CITY OF ALBUQUERQUE

July 24, 2017

**Re: GAHP Casa Feliz
421 Espanola Street SE
Request for Permanent C. O. – Not Accepted
Engineers Stamp Date 12/18/15 (L19D073F)
Certification dated: 7/18/2017**

**CD-208**

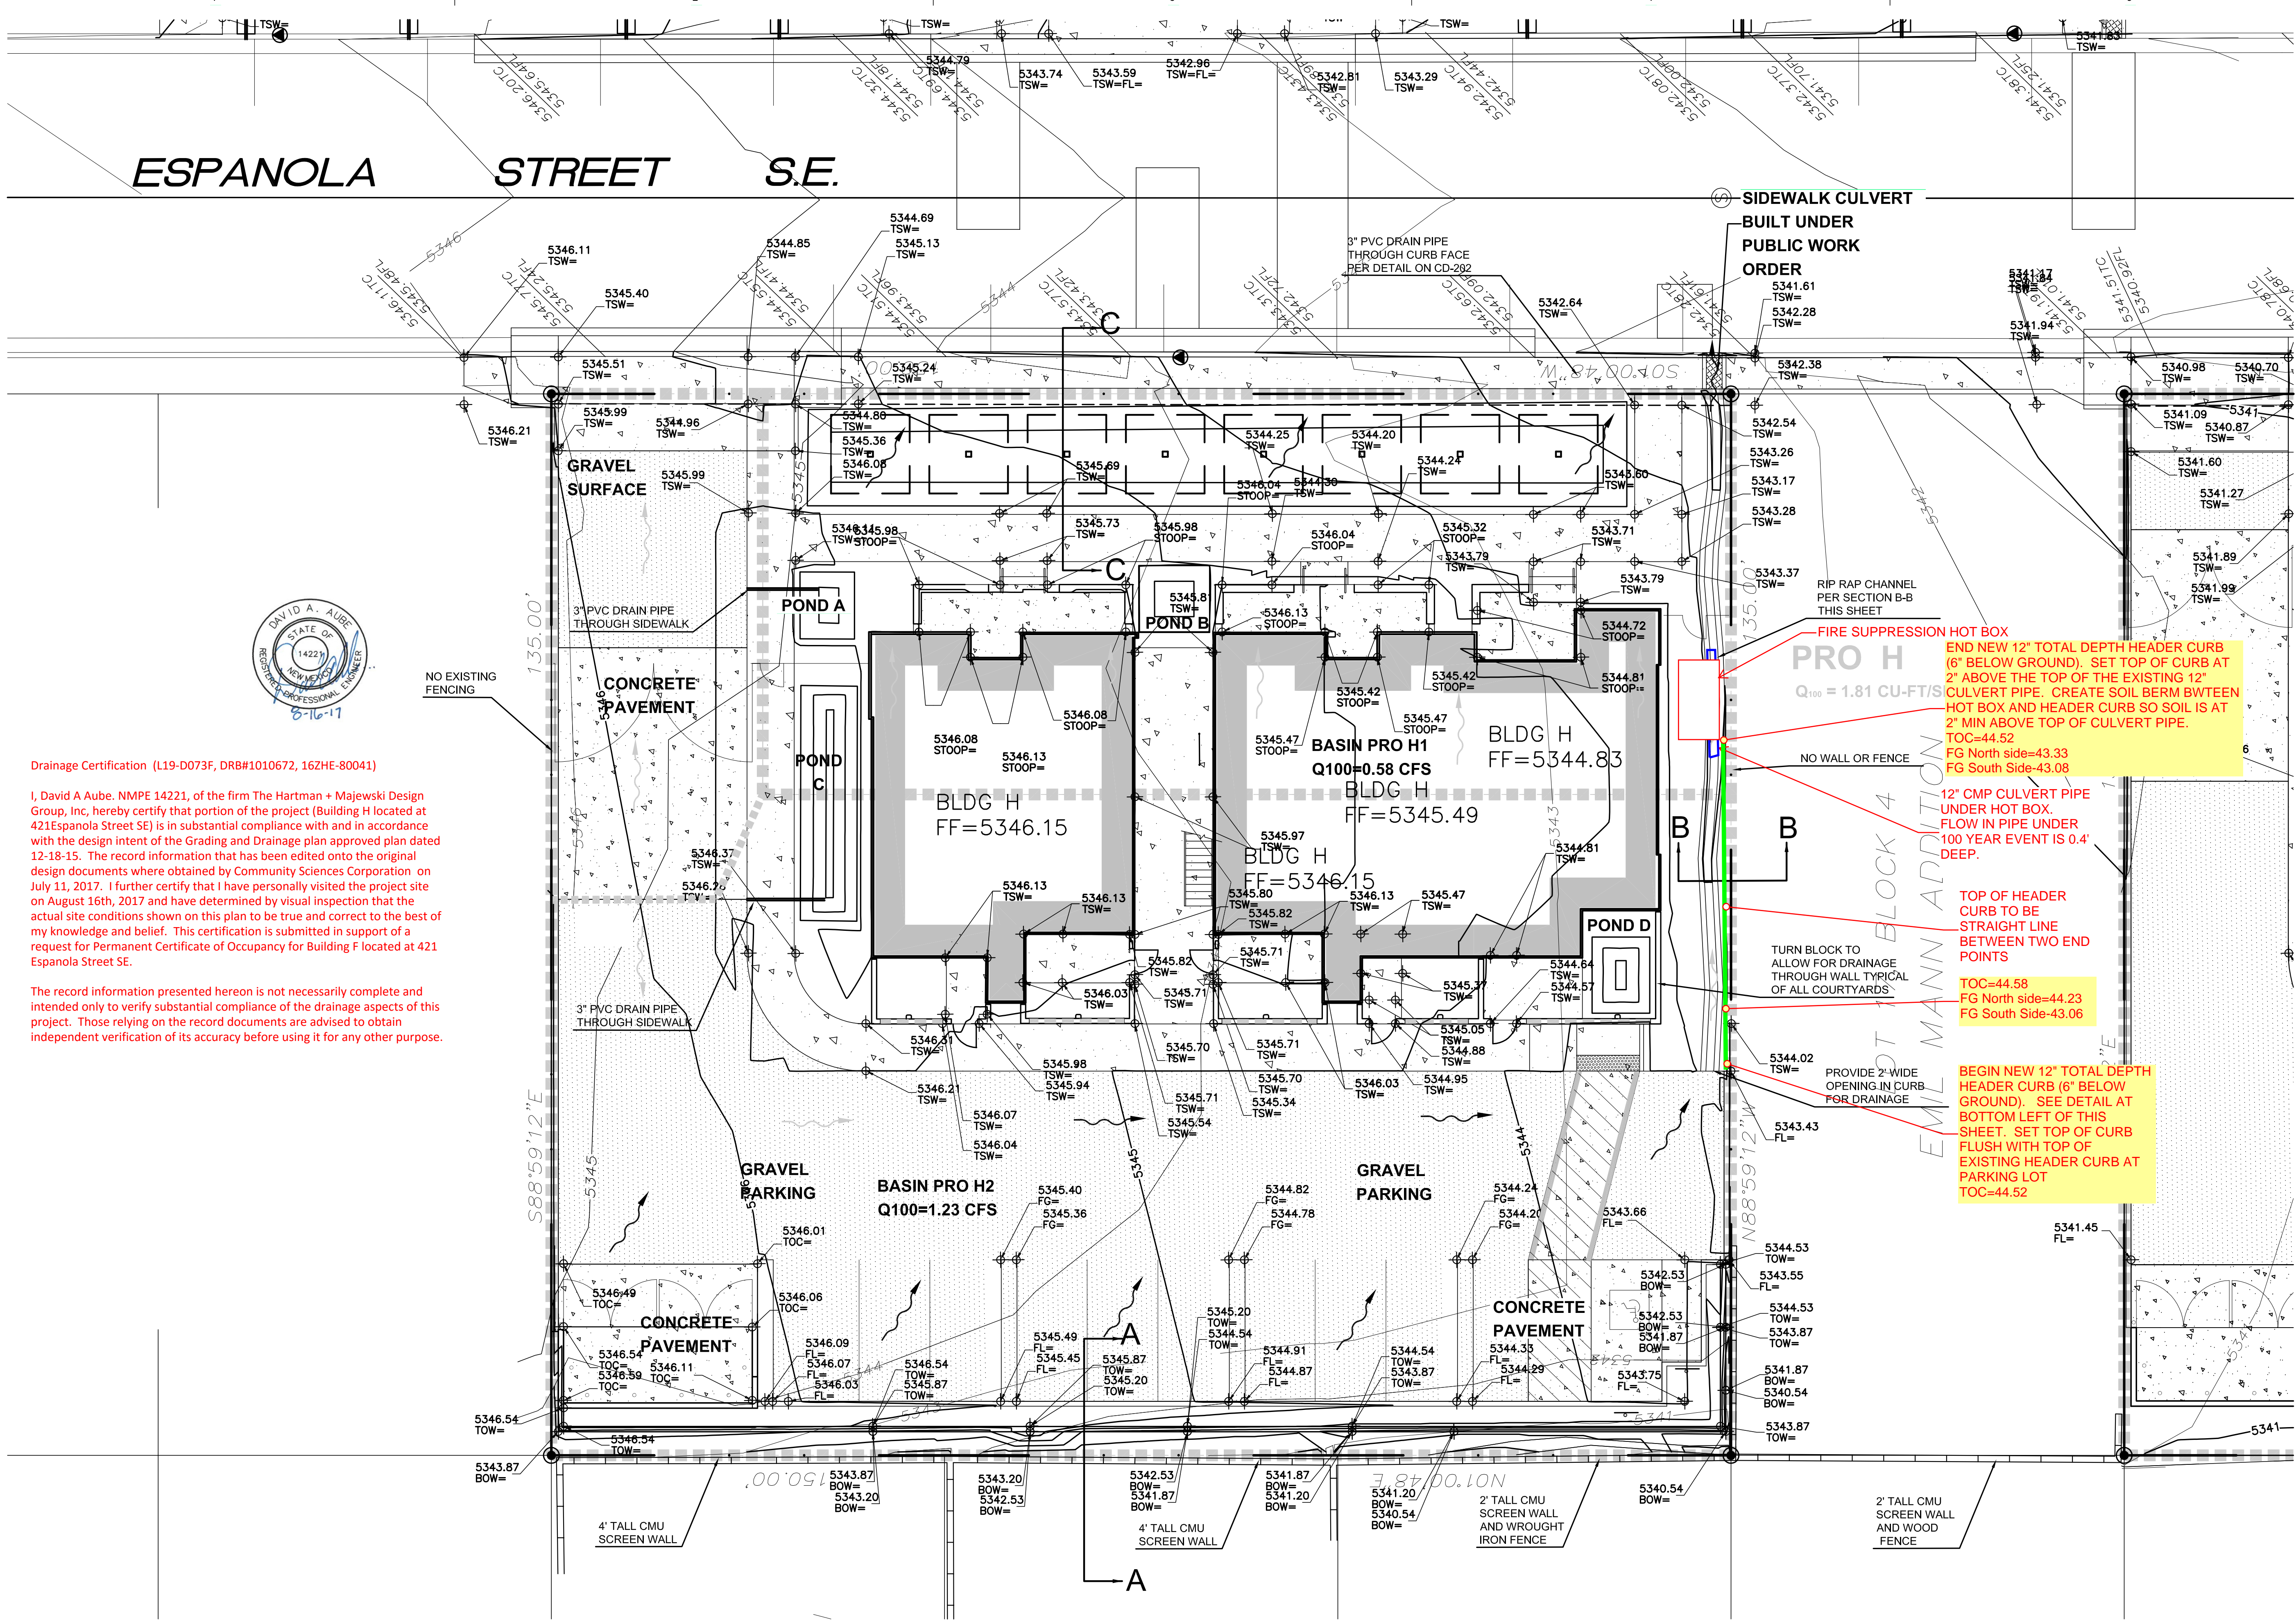
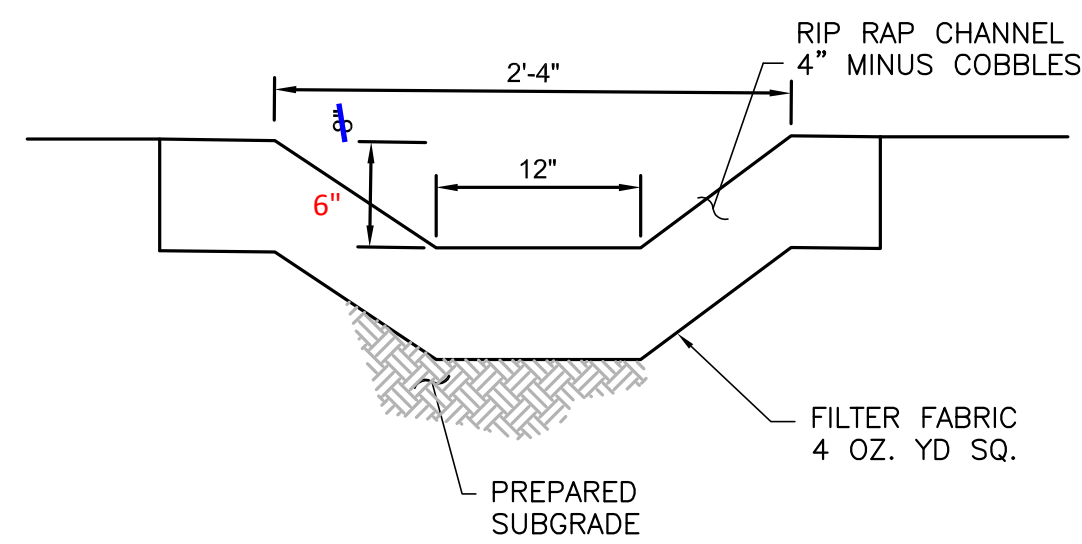
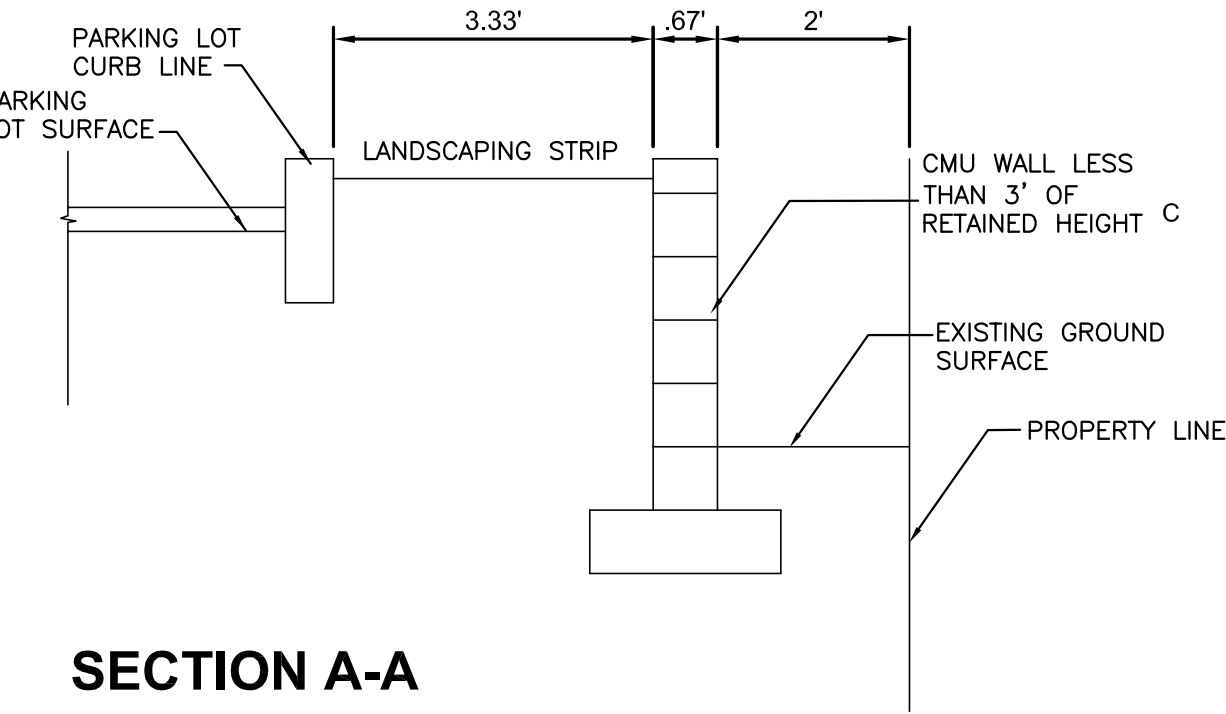
1. Even though your certification and associated survey claims a 6" deep channel on the south side of the site, at our site meeting on 7/20/2017 it appeared that most of that depth is loose landscape rock that won't hold water. So the Grading Plan must be revised and resubmitted to hydrology to include a design of a wall or curb along the south property line as necessary to prevent cross lot drainage. The revised plan should include a new engineer's stamp date.
2. The revised plan should also include a cross-section through the swale and property line and show this sit 1' higher than the adjacent site as shown at section D on the surveyed sections. Manning's "n" value in the channel calculations also needs correction from 0.025 to 0.045 for rip-rap.

1. The pipe that was added in the side yard swale can either be added to the revised G&D Plan or added to the subsequent Engineer's Certification, but it must include invert elevations at both ends and the flow depth must be revised and the pipe must be analyzed as a culvert instead of the normal depth calculation in 6/28/2017 submittal.

2. As-built survey information should be added to the plan to include spot elevations throughout the parking lot, the swale , and the finished floor elevations as well as the top of the new wall to be added on the south side of the property.
